**Lead Local Flood Authority**

Date 24 July 2025

**RE: BE/16/25/RES – Land at Oldlands Farm, Newlands Road, Bognor Regis, PO22 9NN**

Drawn:	J.Arnold	Reviewed:	T.Jones
BWB Ref:	243912	Date:	29.11.24
Scale@A1:	1:500	Status	Rev
FOR COMMENT			
Project - Originator - Zone - Level - Type - Role - Number			
243912-BWB-EXT-XX-D-C-0530			
S3 P01

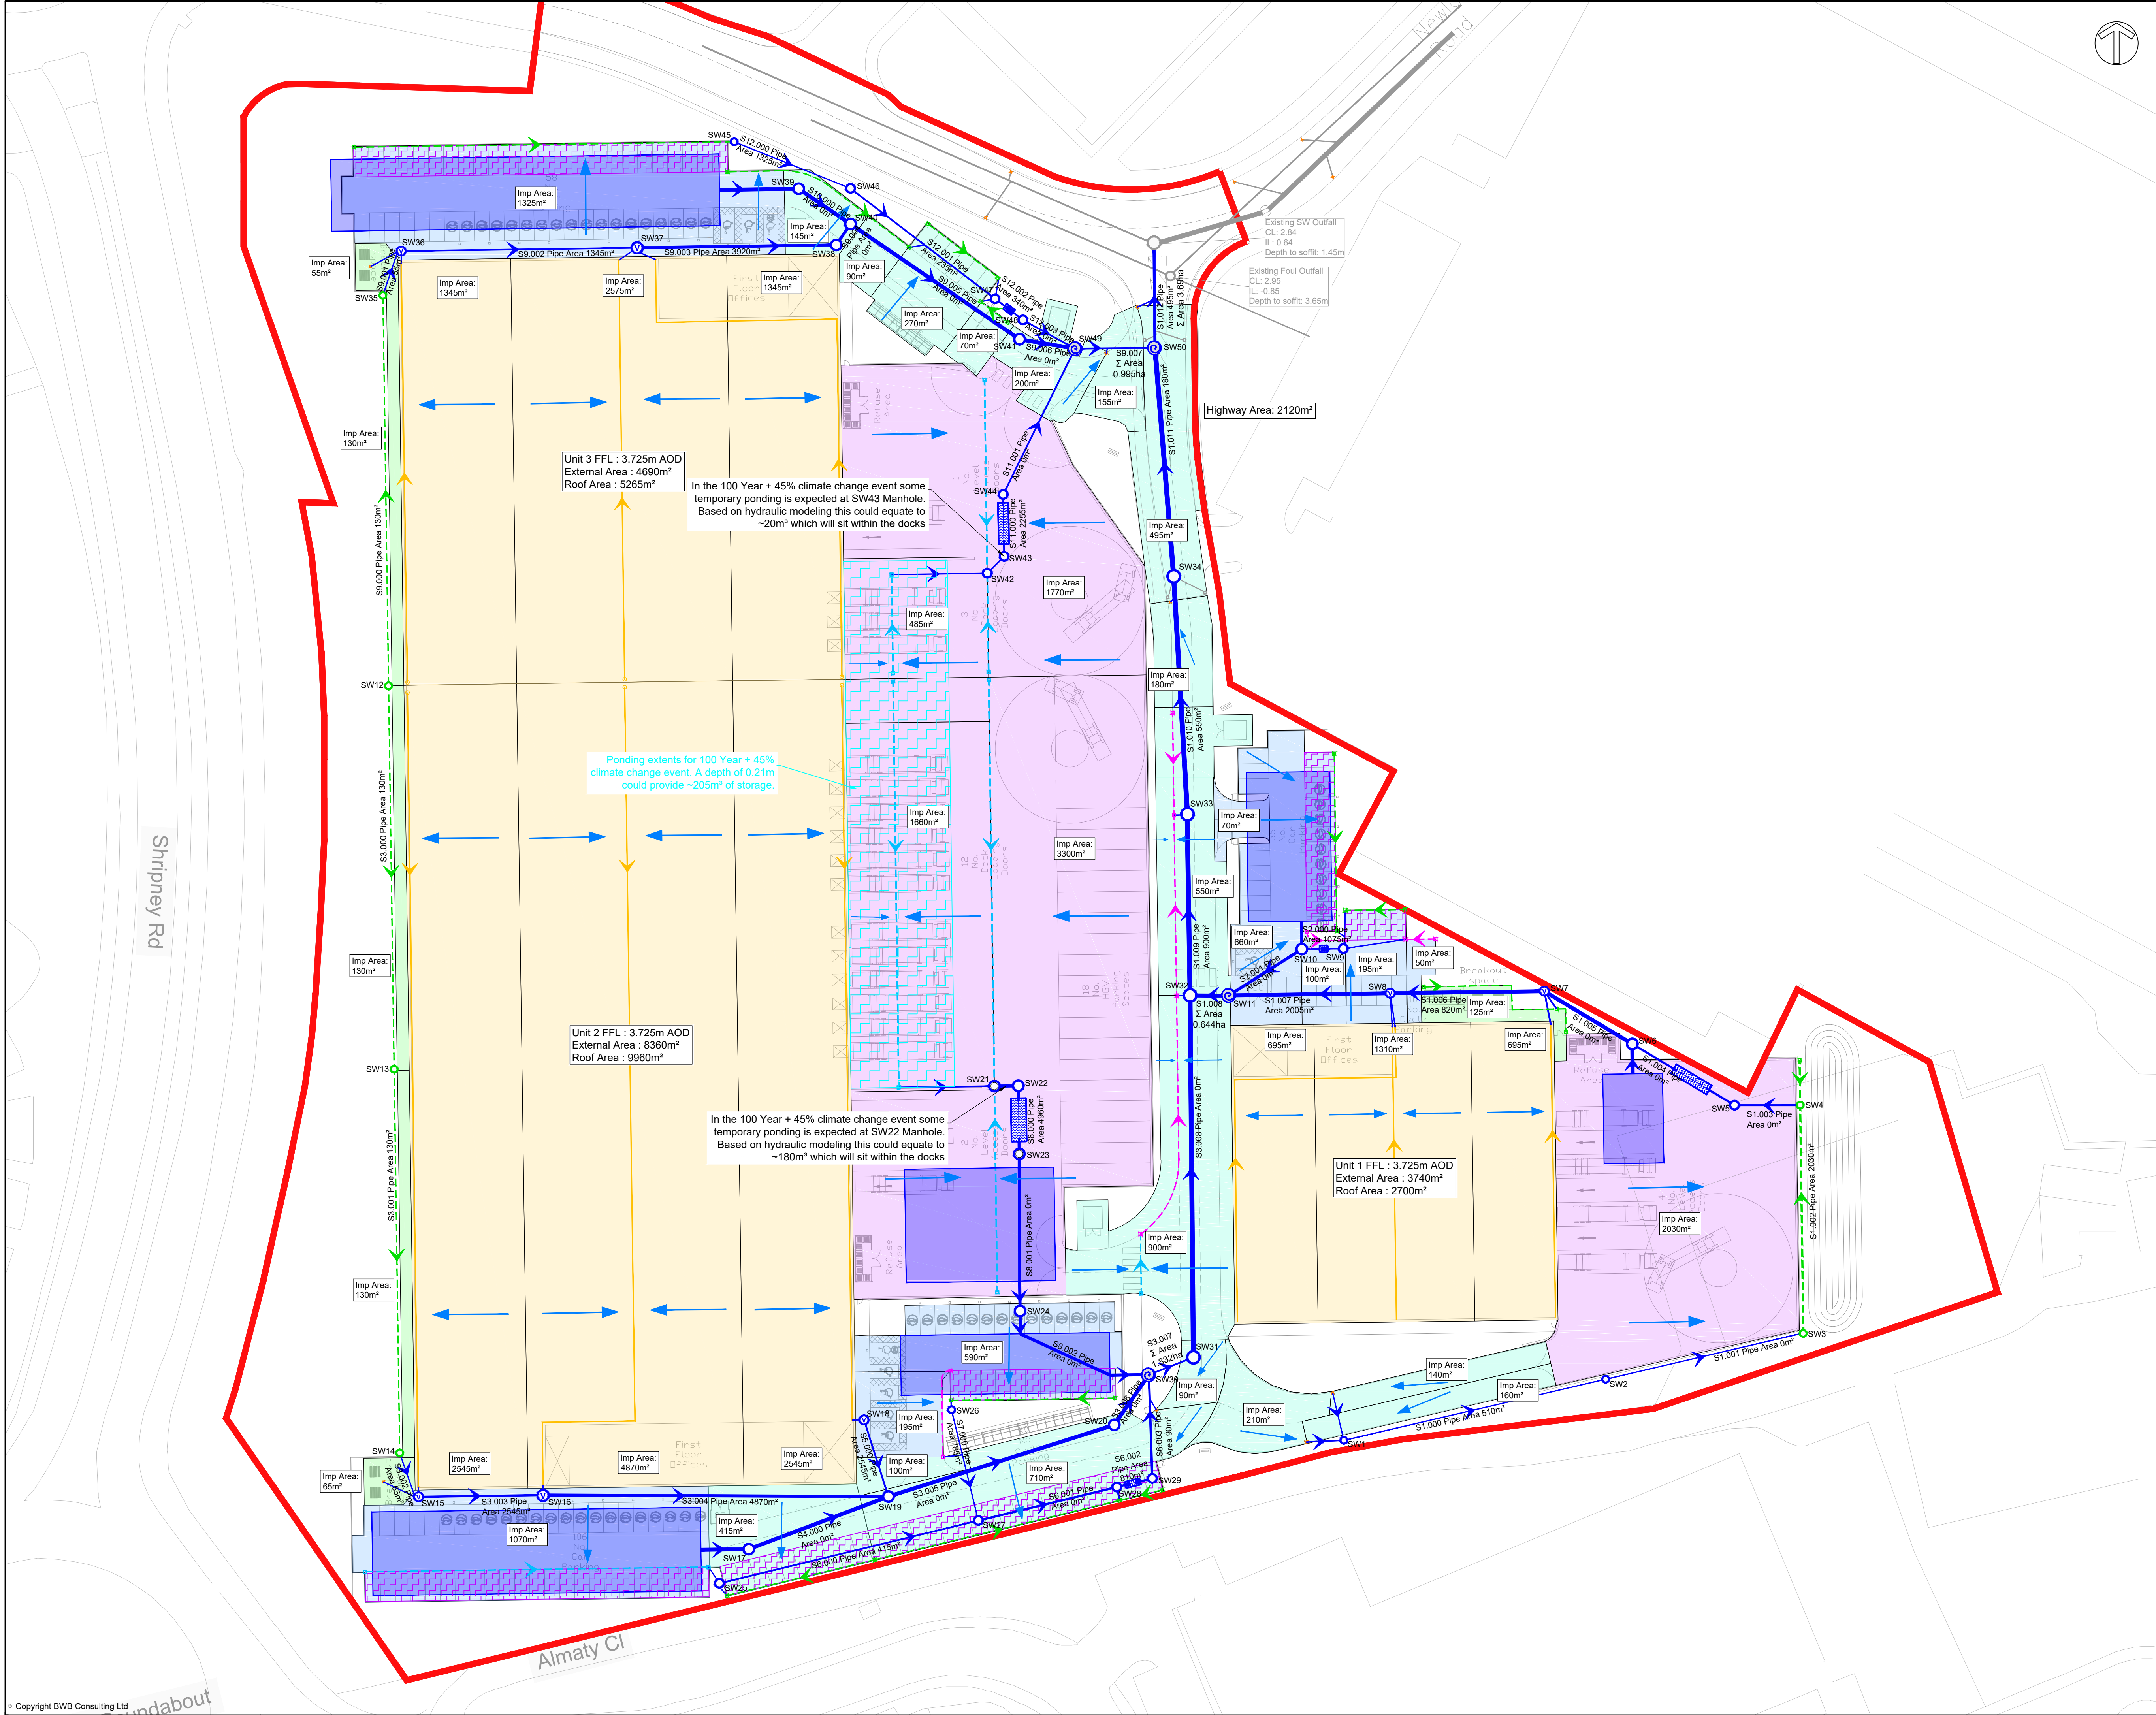
The Drainage Catchment Plan and Technical Note outlines the same drainage and flood risk principles as the original design. The drawings would be considered to be of sufficient detail for reserved matters application stage (i.e. impermeable area, location of tanks and sizes and permeable paving). The discharge rate is being mirrored to greenfield runoff rate (included in the Drainage Infrastructure Technical note). However, we are significantly concerned regarding the flooding on site.

Whilst we note that the main body of the technical note labels this minor flooding, there are multiple nodes on site flooding in the 3.33% AEP (US Node 25 and 43), 3.33% AEP

plus 40% climate change allowance (US Node 12, 13, 14, 15, 18, 25, 26, 1, 4, 35, 45 and 50), 1% AEP plus 25% climate change allowance (US Node 12, 13, 14, 15, 18, 25, 26, 22, 1, 4, 35, 36, 45 and 50) and 1% AEP plus 40% climate change allowance (12, 13, 14, 15, 18, 25, 26, 22, 1, 4, 34, 35 36, 45, 50) respectively. The LLFA would not deem this to be minor flooding on site. We require justification for said flooding. On this basis, we **object** to this reserved matters application.
